3rd Update Report (June 2024)

This report has been prepared to assess the evidence provided for the discharge of Conditions 13, 20 and 36 of Outline Application 14/02121/OUT amended by 22/03492/NMA for Phase 2 of Himley Village. Additionally, this report assess updated information required to comply with S106 Schedule 11 (Zero Carbon) from 23/02786/OBL.

Figure 2 - Proposed EUI breakdown for the Himley Village development

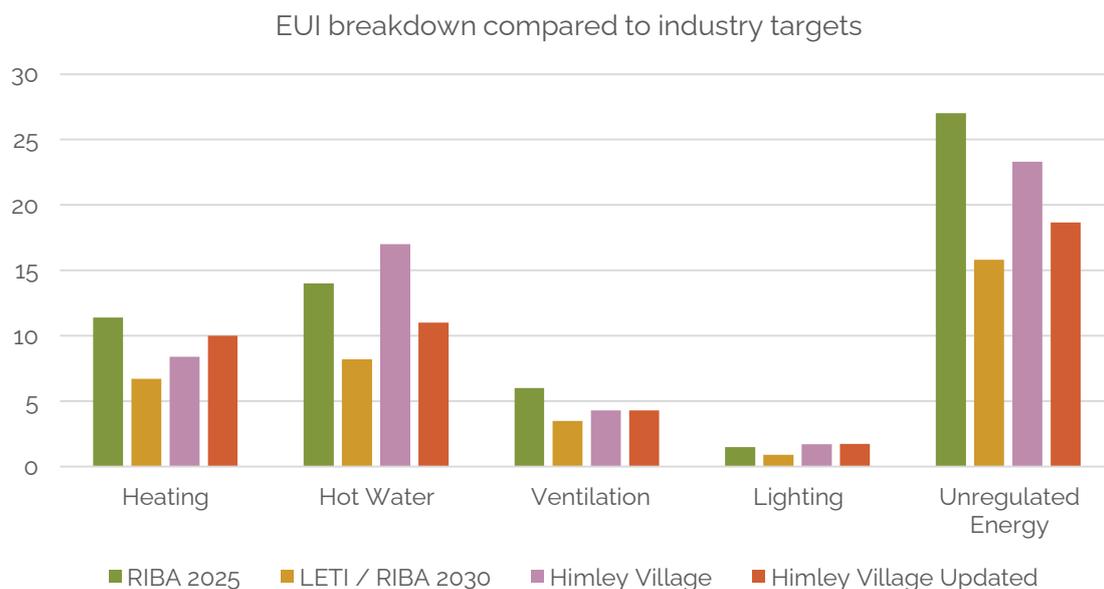
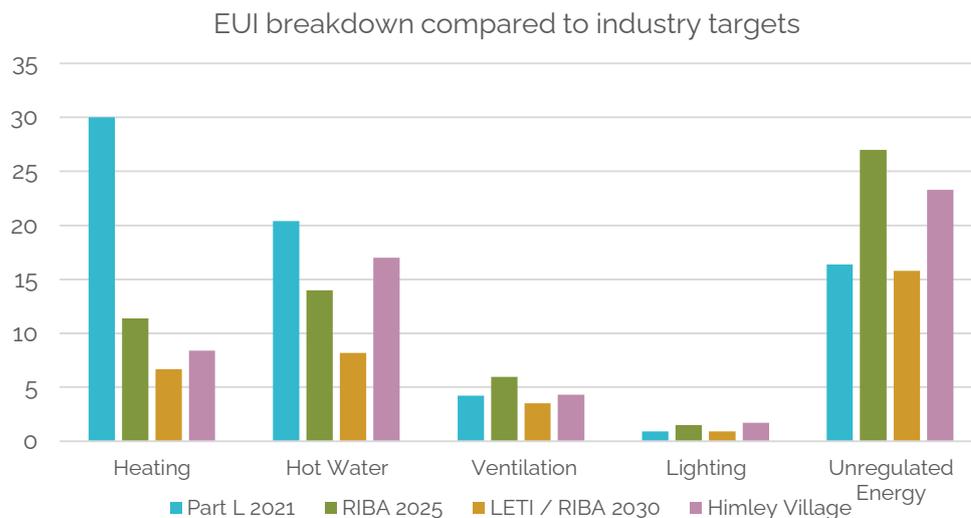
The reduction from 23.3 kWh/m²/yr to 18.7 kWh/m²/yr was not explained in the Energy Strategy Addendum but has been explained in the May 2024 Energy Strategy. Reasoning for the reduction is attributed assuming 2 weeks of annual household absence for holidays, intermittency of fridge/freezer output and rationalisation of white goods. The first reduction attribute is acceptable in principle but the level of unregulated energy consumption reduction assumed from the three reduction measures is excessive and not sufficiently explained. Given that the EUI of the modelled dwellings is 45.7 kWh/m²/yr and the PV output of the phase is 46.9 kWh/m²/yr, it is essential that the reduction in unregulated energy is sufficiently justified since it is this reduction in energy consumption that has achieved the true on-site zero carbon definition – i.e. without the reduction to 18.7 kWh/m²/yr for unregulated energy, the true on-site zero carbon definition would not be achieved and the development would therefore be non-compliant with policy. Further detail is required on the remaining two measures to reduce predicted unregulated energy consumption and the individual contribution of each of the three measures towards achieving the 4.6 kWh/m²/yr reduction.

In addition to the measures previously outline – we had rationalised the equipment as there was double counting in the number of screens related to the home office. Tumble dryers were also omitted as these will not be provided as part of the development.

Bioregional confirm this has been addressed. Additional commitment to ensuring unregulated energy assumptions will occur in practice has been issued.
